Engineers Comments Regarding Surface Water Drainage

Application Reference:	AL/103/25/DOC	Reviewer Reference:	ADC/EXT4
Planning Officer:	Simon Davis	Date of Review:	04/12/2025
Site Name:	Land Adjacent to Woodgate Nurseries Lidsey Road Aldingbourne		
Application Description:	Approval of details reserved by condition imposed under AL/129/21/OUT in relation to conditions 16-Surface Water Drainage Scheme, 17-discharge flows to watercourses and 18-maintenance and management of surface water drainage.		
Assessment Number:	1 of 2

Application Reference: AL/103/25/DOC Site Name: Land Adjacent to Woodgate Nurseries Lidsey Road Aldingbourne	Initial Issue Date: 04/12/2025 Issue Date: Reviewer Reference: ADC/EXT4
---	--

Drawing Title:
Phase 1
Storm Water and Foul Water
Drainage Layout.
Sheet 2

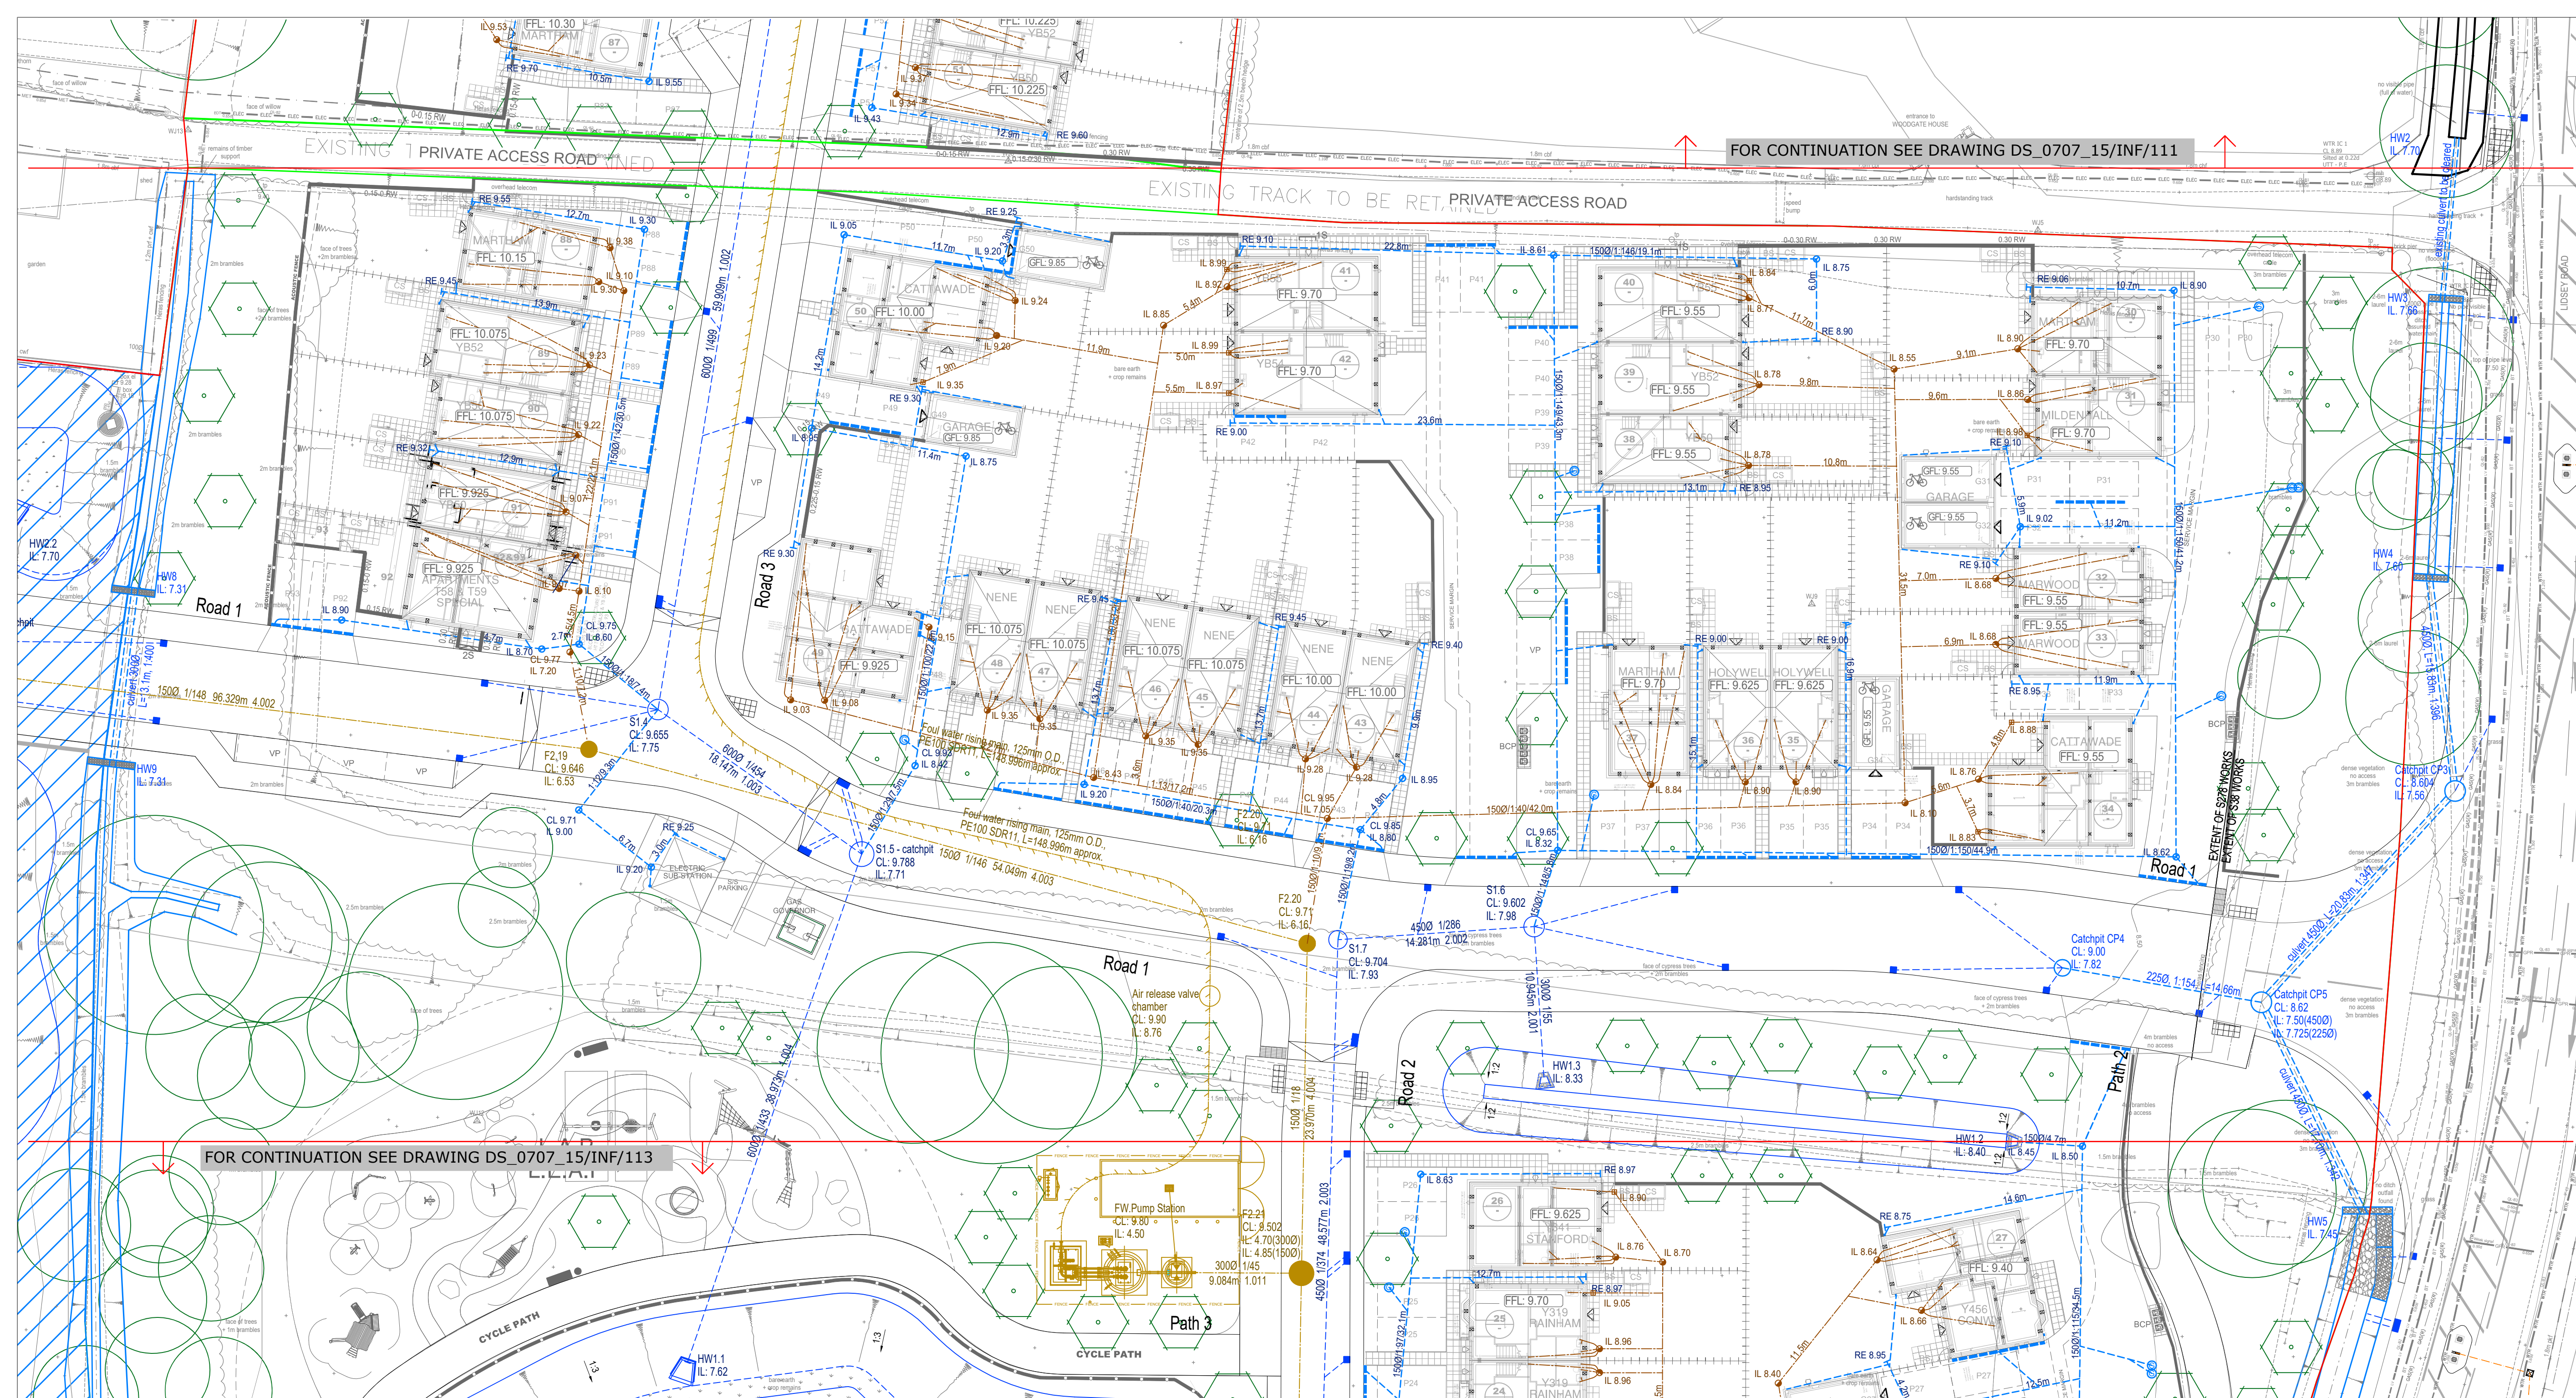
clarification on maintenance operations in in relation to these areas to confirm proposed tree locations will not impede future operations		
8.	Please review extents of drainage runs and clashes with proposed tree planting. There are multiple instances where drainage runs are shown to clash with new trees for eg.. outside plot 22, plot 18, plot 16,50,52,53,55, 56, 85 etc...	Tree locations shown previously don't tie in with the latest landscaping layout. Please find enclosed drainage layout drawings: DS_0707_15/INF/111-113. Some clashes still occur, but there is ongoing coordination between landscape designers and civil engineer, and any existing conflicts are to be resolved before construction phase of the project	Updated information is required as part of the conditions. This information needs to be co-ordinated now

Foul Water Rising Main Long Section

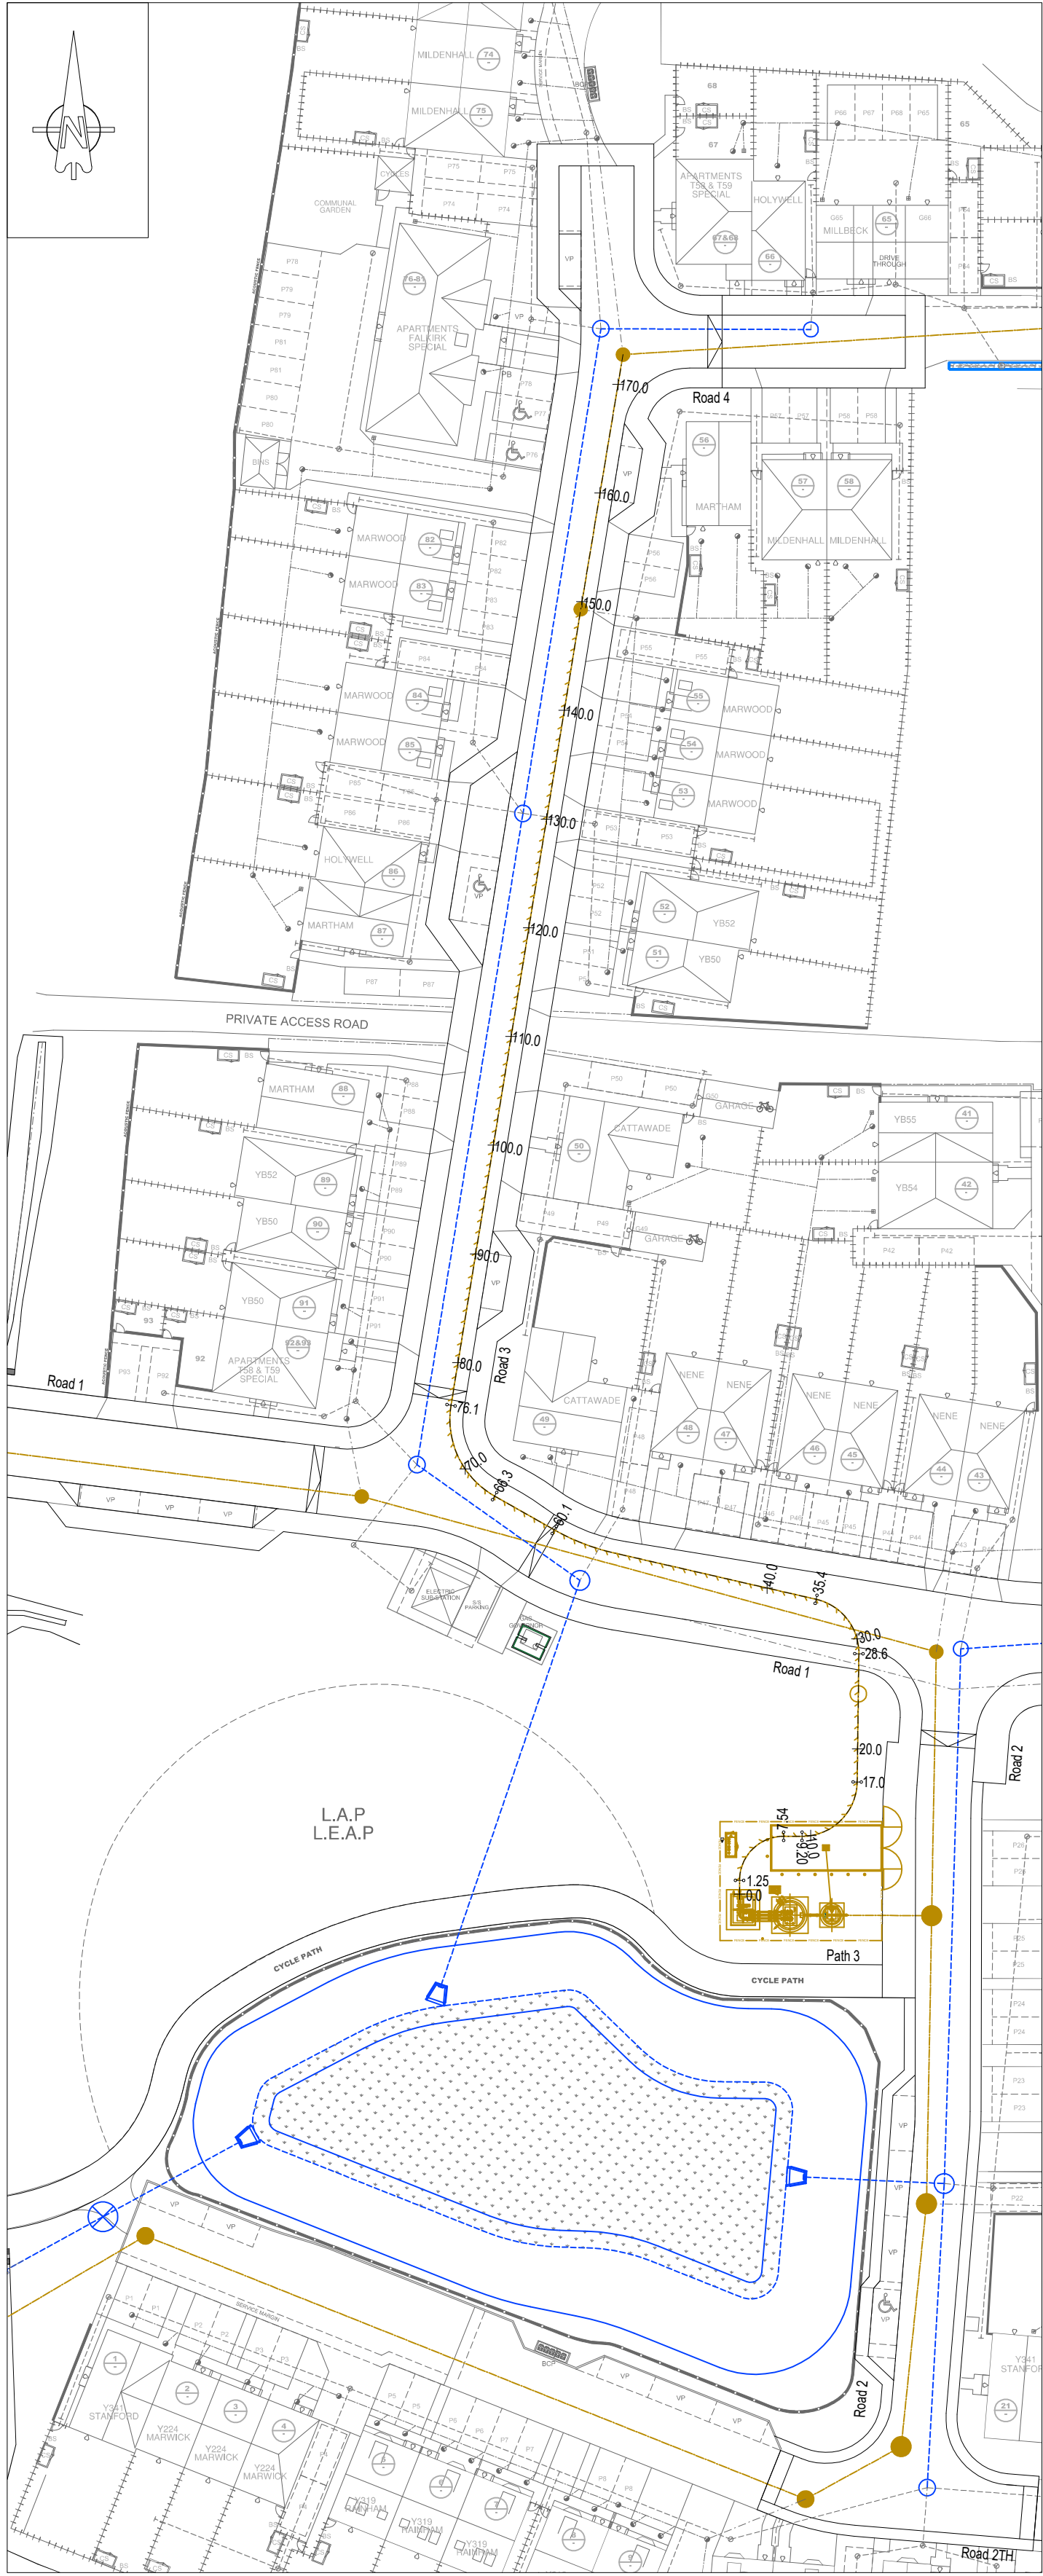
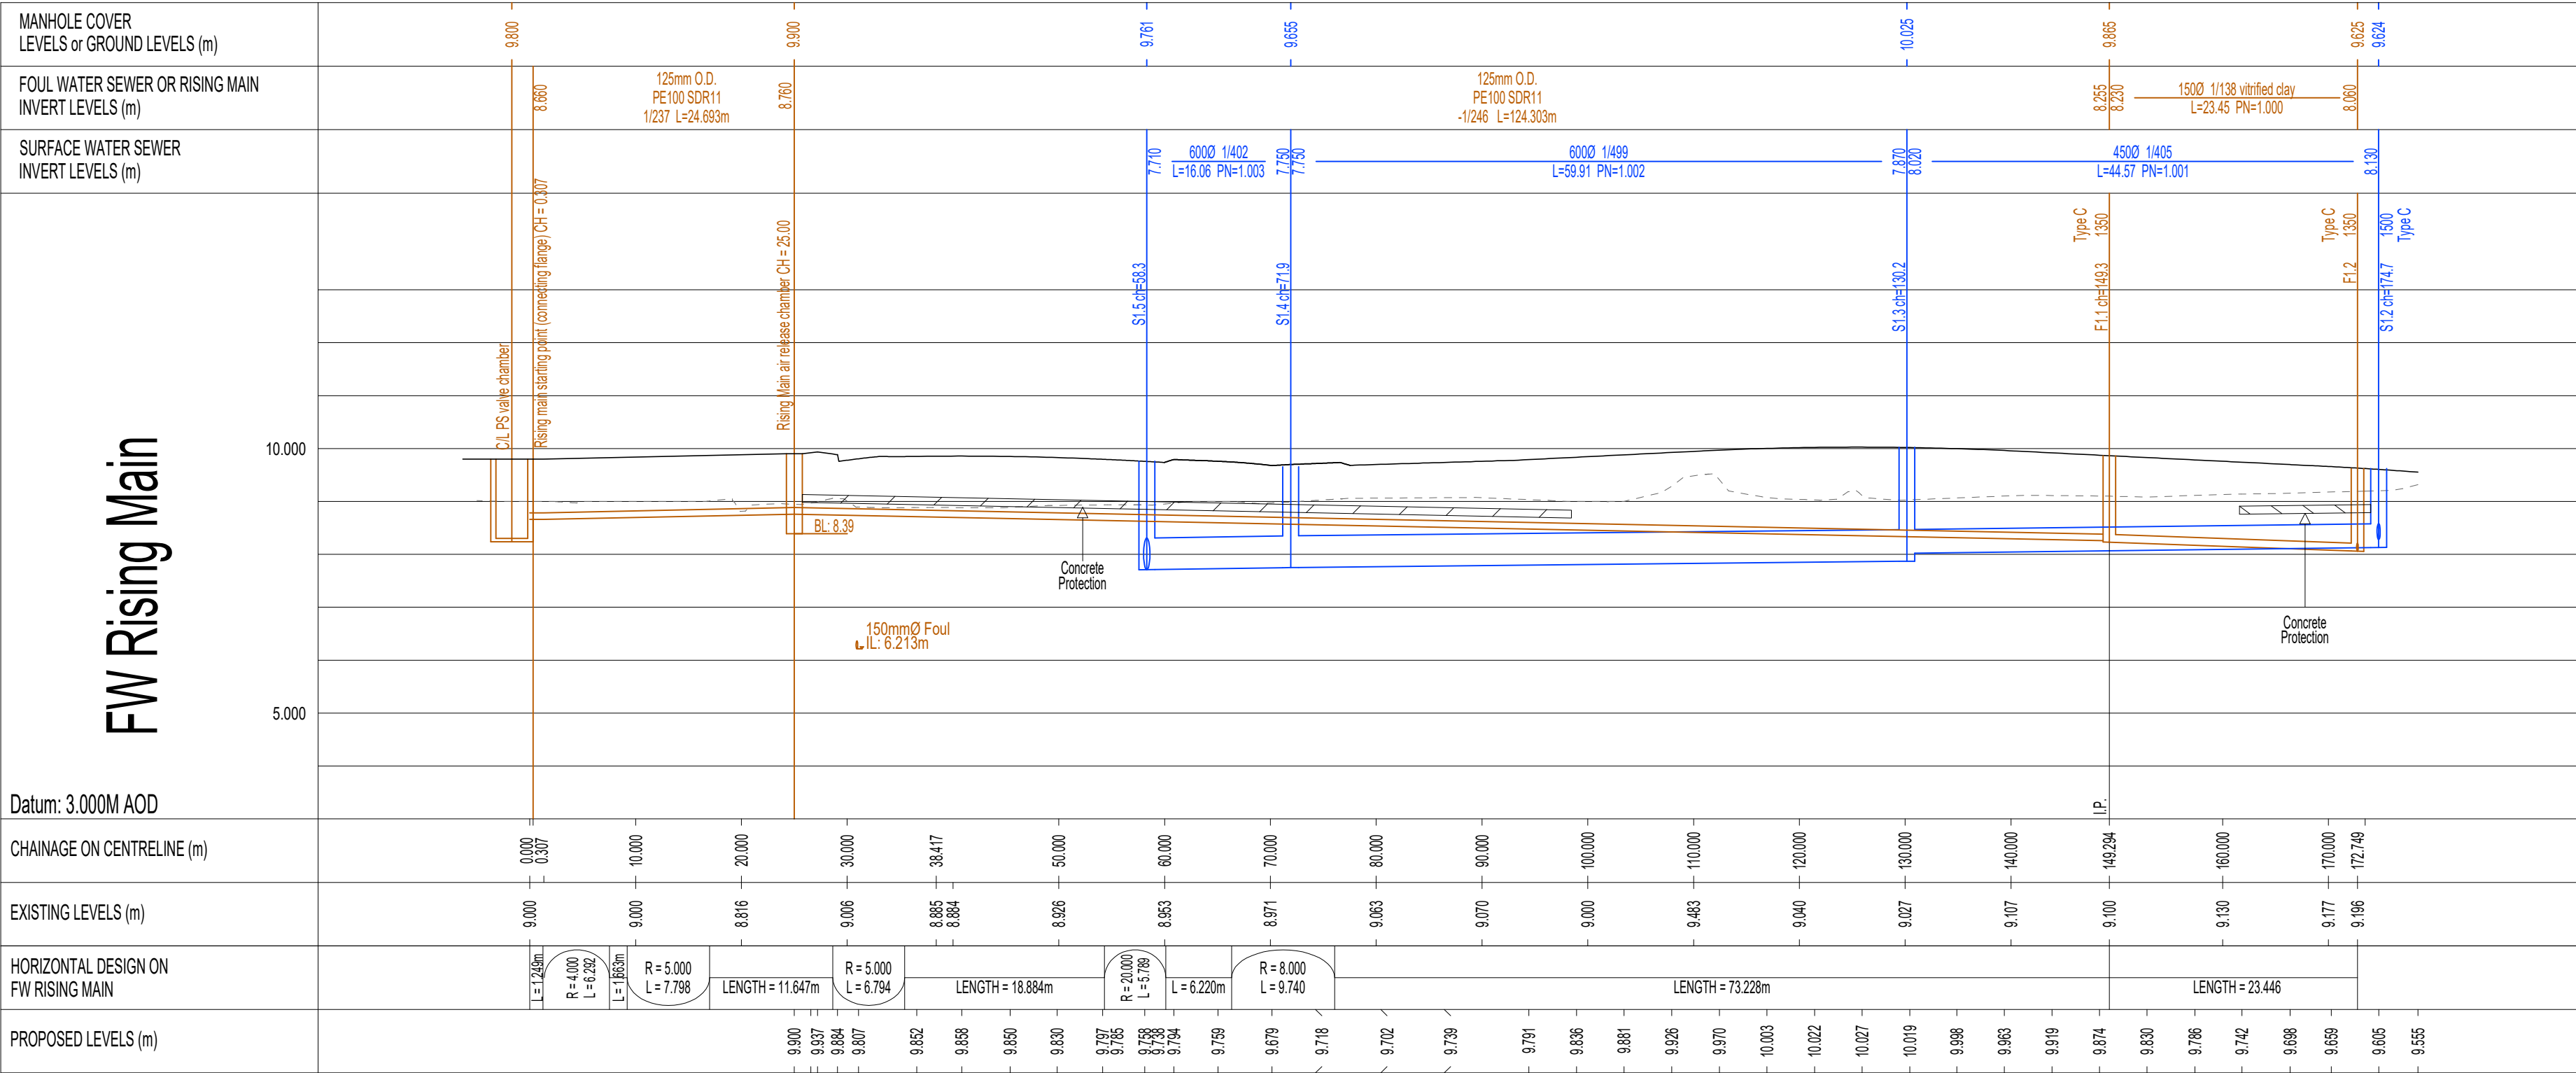
12.	Please provide site sections with levels	Please find enclosed long section drawings: DS_0707_15/INF/121 to 124	Noted item closed		
13.	Please provide sections and details for both attenuation basin and swale	Please find enclosed drawing: DS_0707_15/INF/115	The details are insufficient and do not correlate with specific requirements identified in RSK Basin calculation report. Detailed construction sections, clearly specifying depth of liner to address buoyancy and backfill depth needs to be provided. Its clear that shallow groundwater is an issue on this site and this construction detail is
